MONA OFFSHORE WIND PROJECT

Schedule of Changes to the Change Request: draft Development Consent Order

Application Reference: EN010137

Document Reference: S_CR_12

Drawing Title:
STREET WORKS AND ACCESS TO WORKS PLANS - SHEET 11

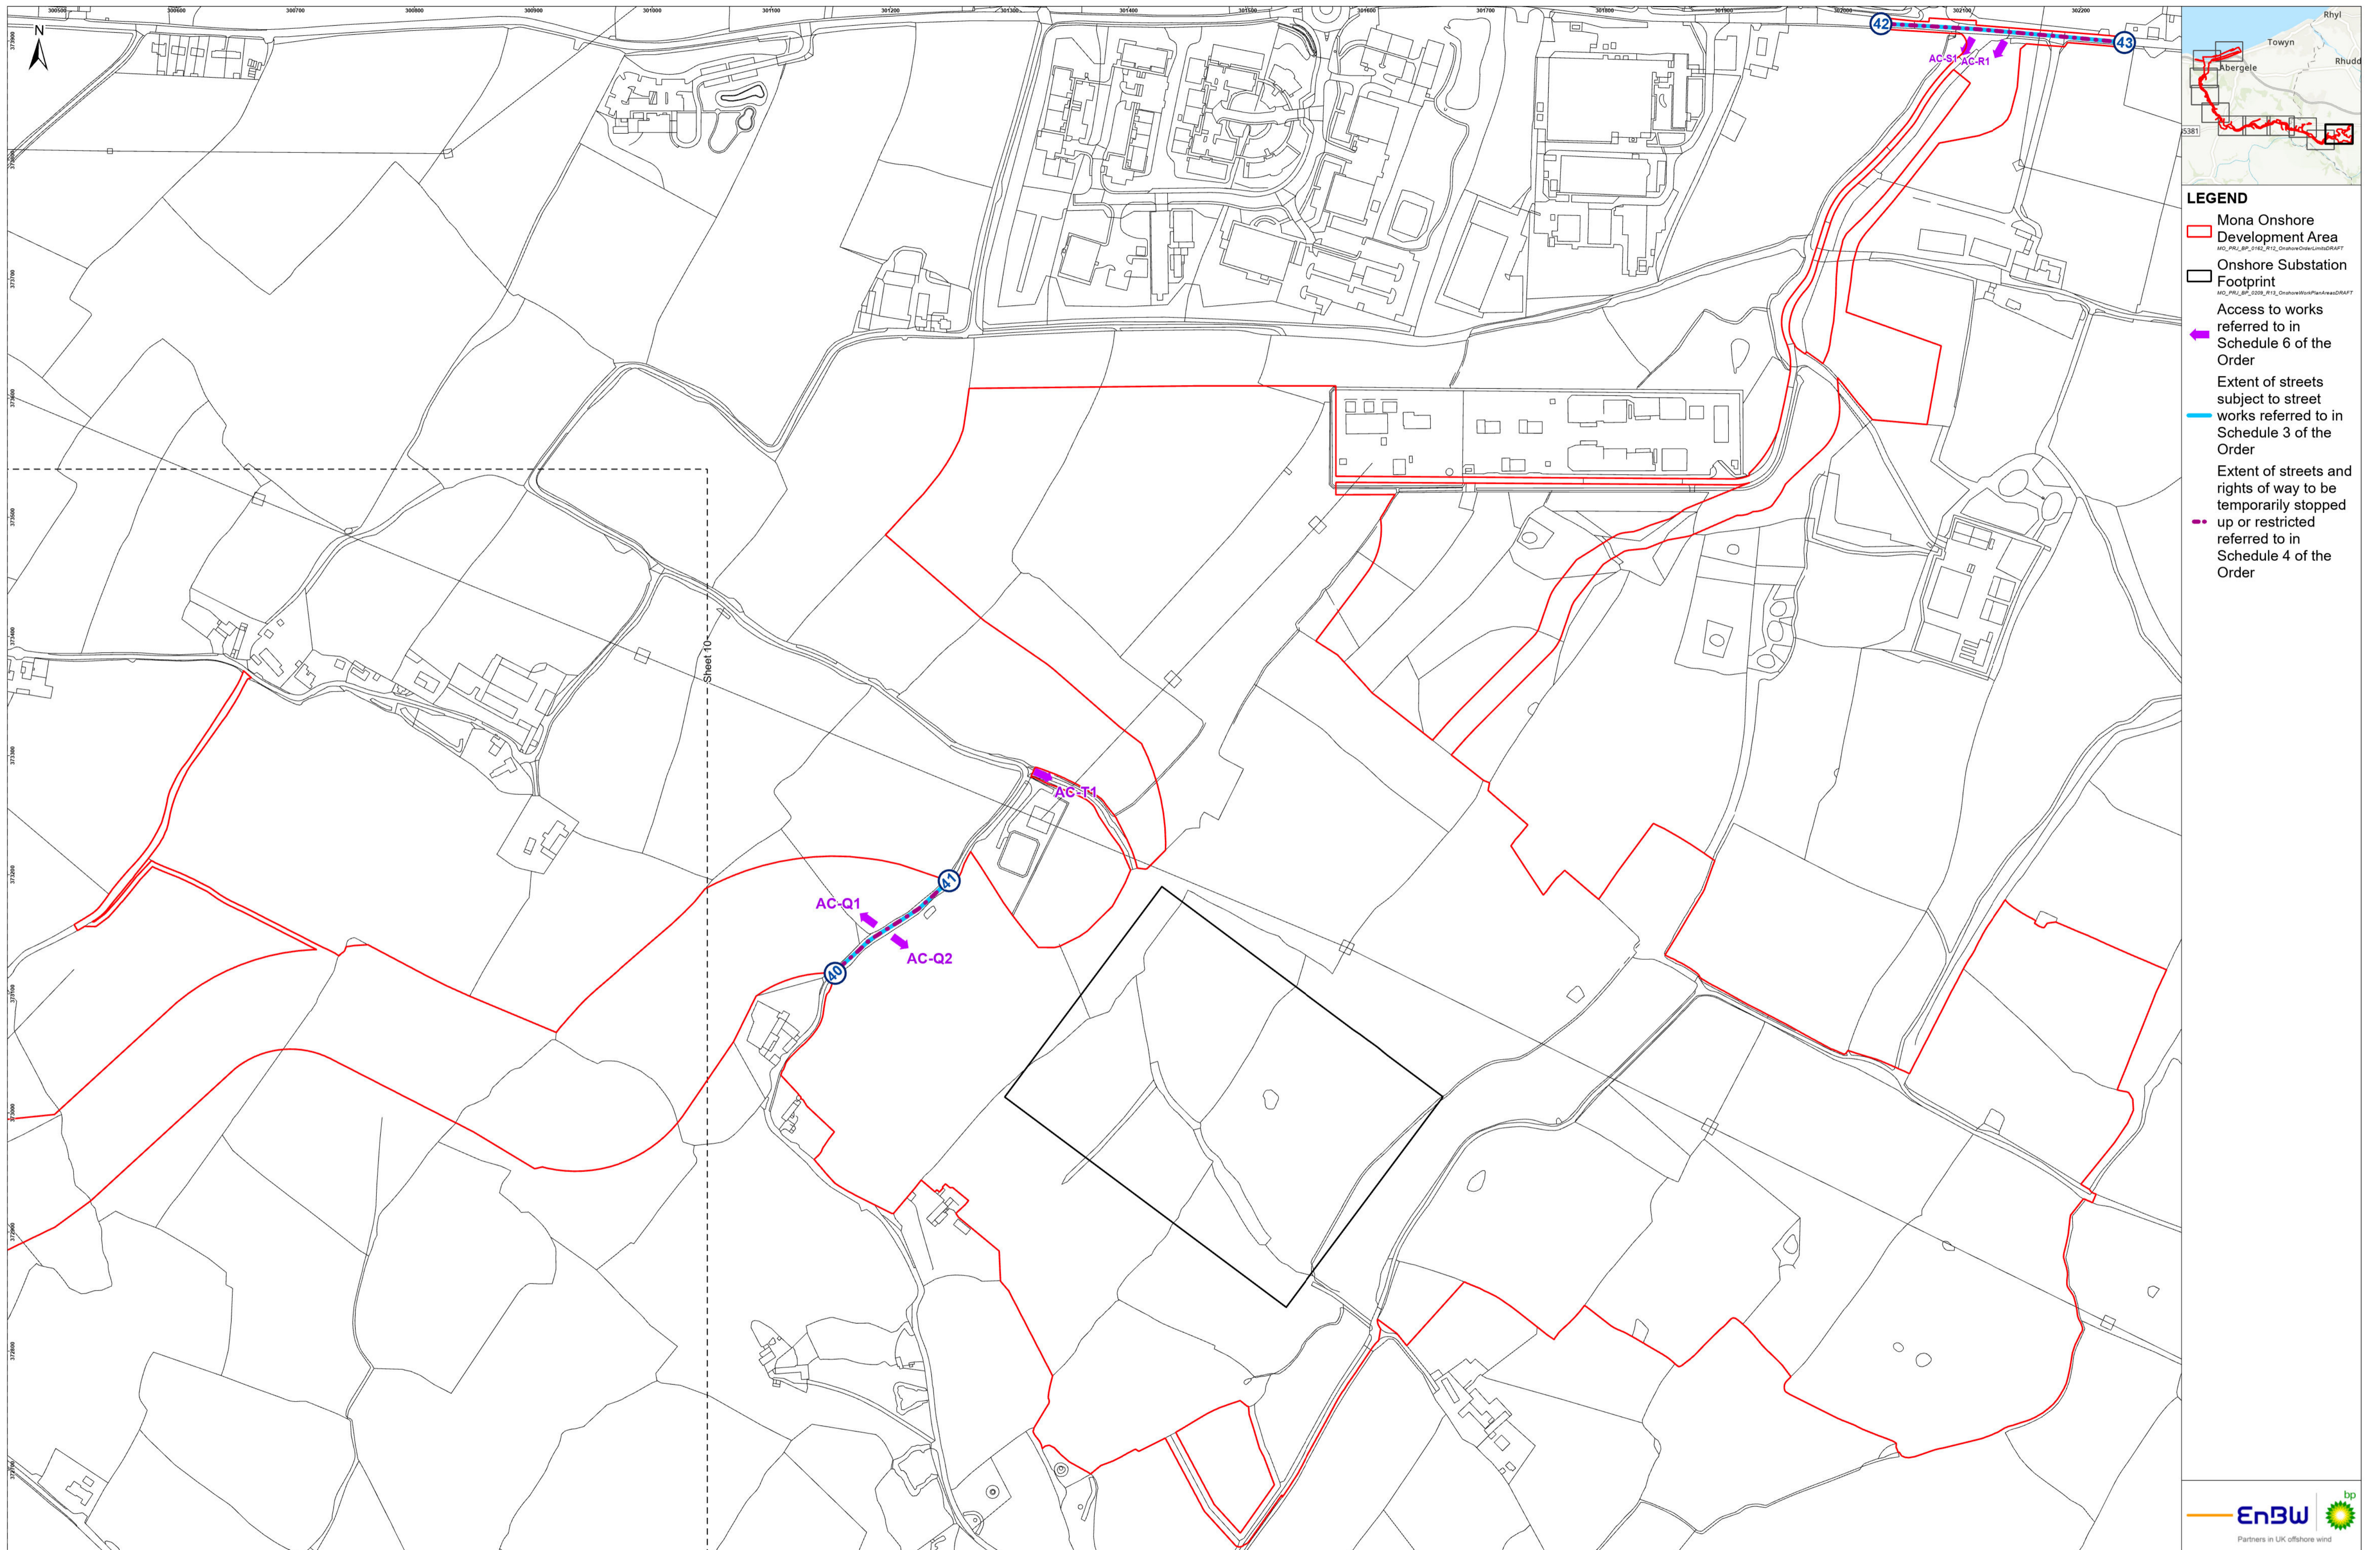
Article/Paragraph/Schedule Number	Amendment	Reason			
<p>Schedule 6</p>	<p>A row has been inserted at the end of the table as follows:</p> <table border="1" data-bbox="616 454 1568 534"> <tr> <td data-bbox="616 454 728 534"><i>AC-T1</i></td> <td data-bbox="728 454 1568 534"><i>From public highway unclassified road as shown on sheet 11 of the street works and access to works plan</i></td> </tr> </table>	<i>AC-T1</i>	<i>From public highway unclassified road as shown on sheet 11 of the street works and access to works plan</i>	<p>This amendment is required to effect the changes detailed in the Change Request Report (Document Reference S_CR_2 F01).</p> <p>Whilst there is an updated Street Works and Access Plan provided with this Change Request (Document Reference S_CR_6 F01) to illustrate this change, the draft development consent order has not been drafted with reference to that document. Instead the original definition of street works and access to works plan is retained on the basis that should the Change Request be accepted, that street works and access plan will be updated with the additional access.</p>
